Chippendale Residents Interest Group

20 July 2013

SSD5700-2012 Block 4S, Central Park, Chippendale and associated applications for Block 4N and the Concept Plan). Response to the Proponent's Response to the Submissions made

Solar Access

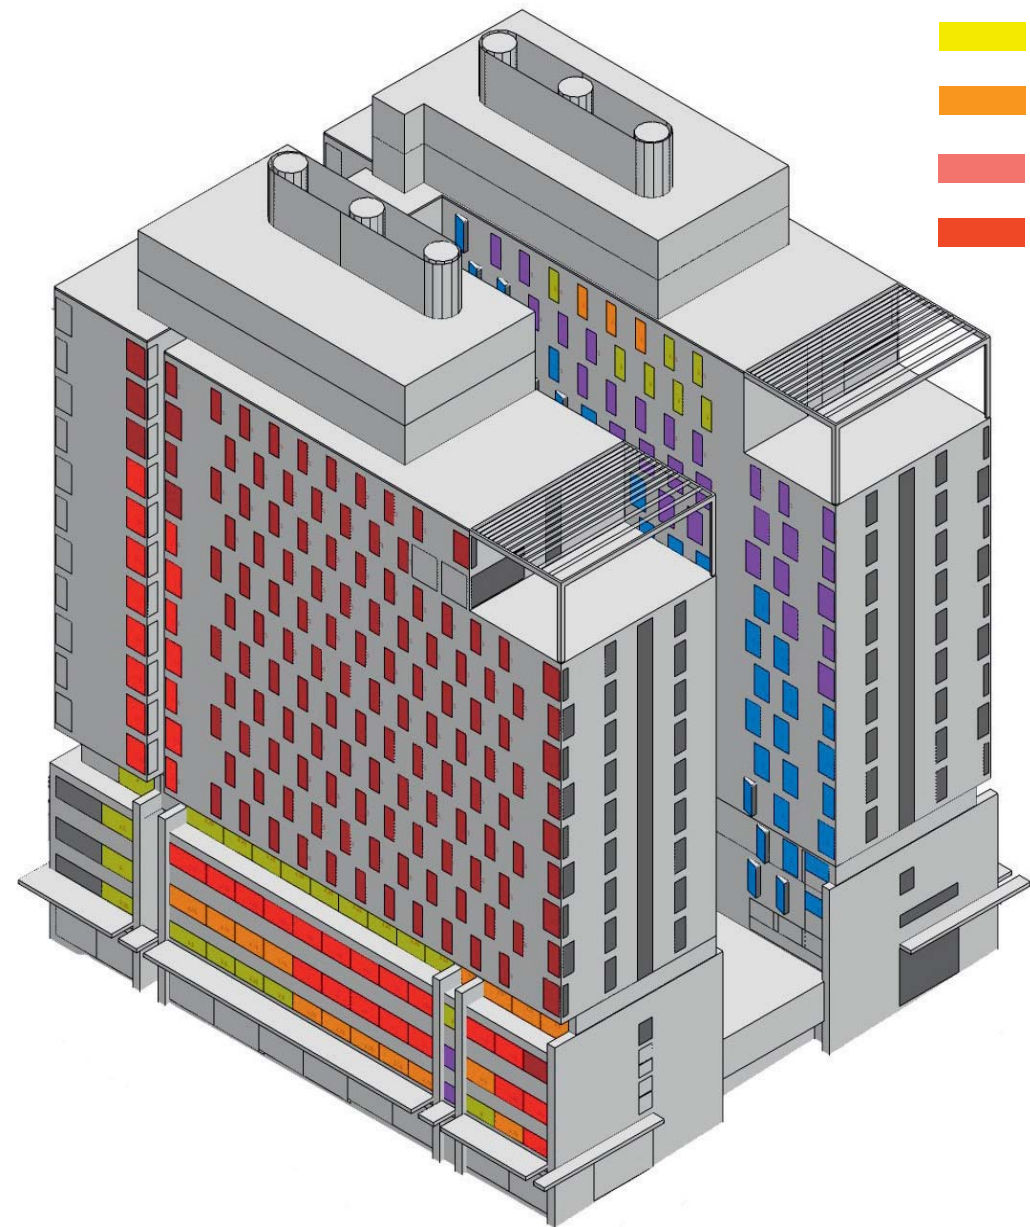
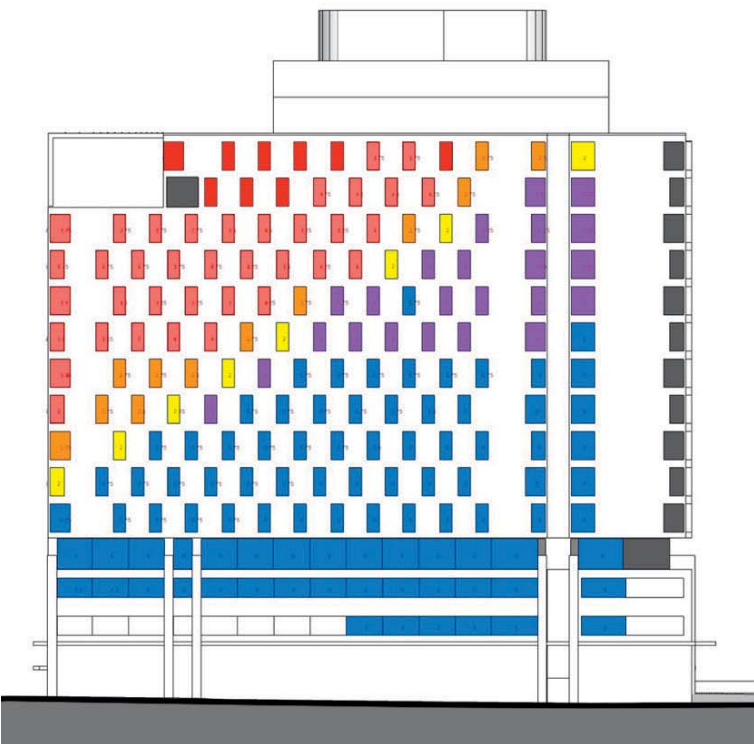
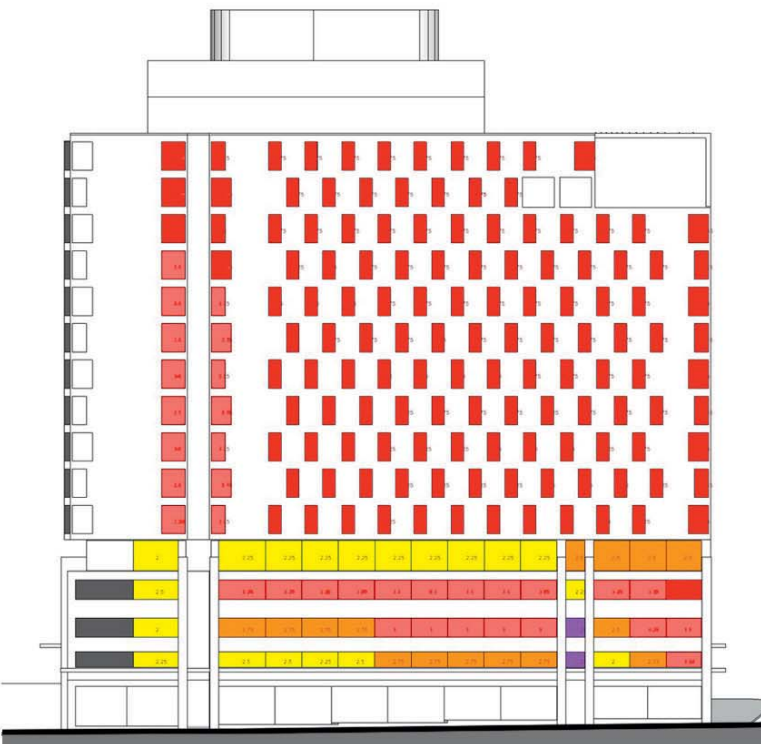
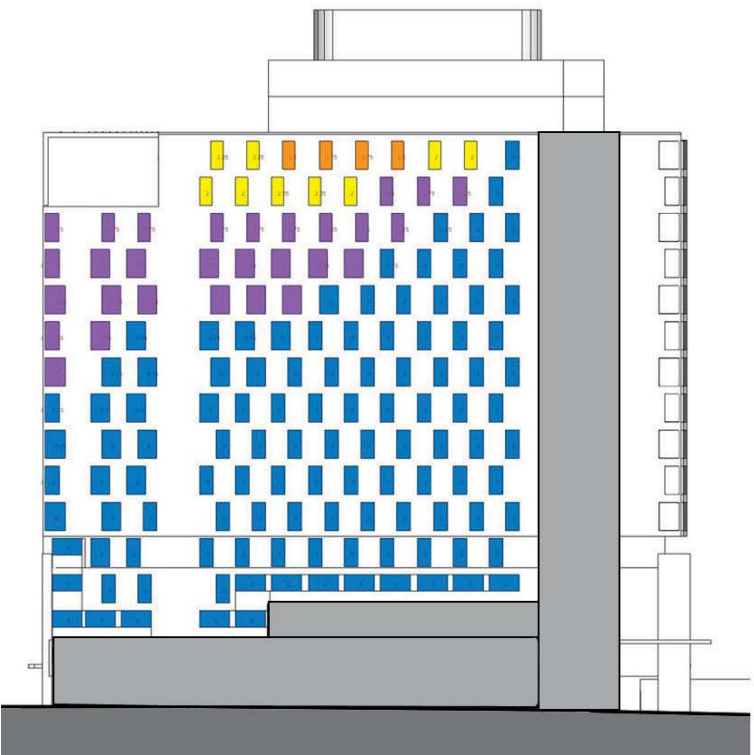
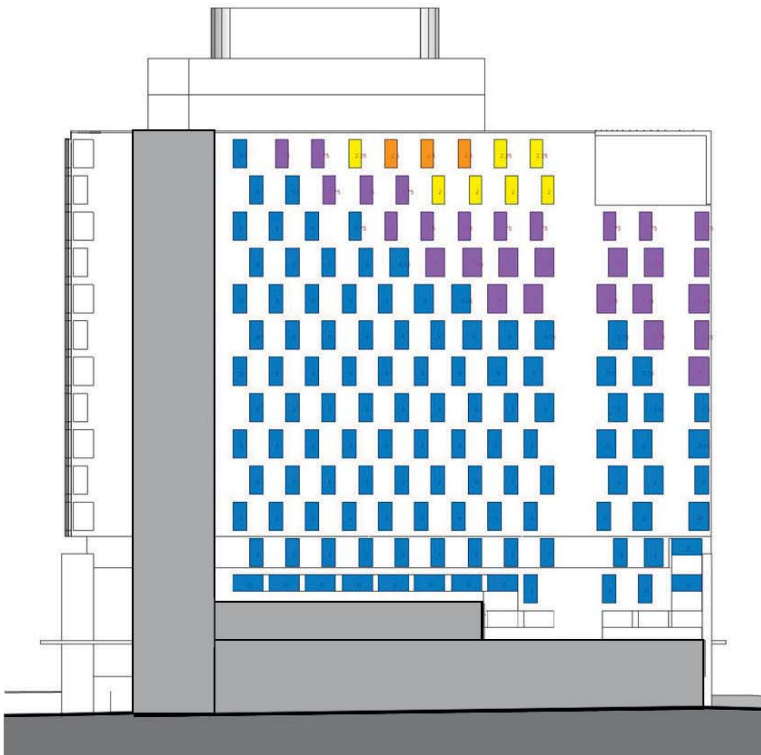
The design does not meet the relevant requirements. Only 42% of the units will receive 2 hours of sunlight in midwinter (with extended hours to capture this; i.e. from 0700 to 1700hrs, not the normal 0900 to 1500hrs). The argument that the students will be out all day is false. Full-time university students typically are on campus 20 -24 hours per week. The remainder of the time, students typically study for long periods of time and at their place of residence. The assumption that Solar Access won't matter to the students because they will be there for short leases only is unreasonable. Further most students will lease their rooms for 6 – 12 months at a time, which is the equivalent of a normal private lease.

Further the proposed privacy screens, reduce solar access and will give the rooms even more of a closeted feel – the solution is inadequate to fix what are essential issues in terms of the design, i.e. the building in its current form and location was not intended as residential accommodation, irrespective if the accommodation is intended as student accommodation or affordable housing (which we note requires the accommodation to be indistinguishable and on par with local accommodation). To suggest that key controls will not be met is inequitable and contrary to the intention of the Act⁷.
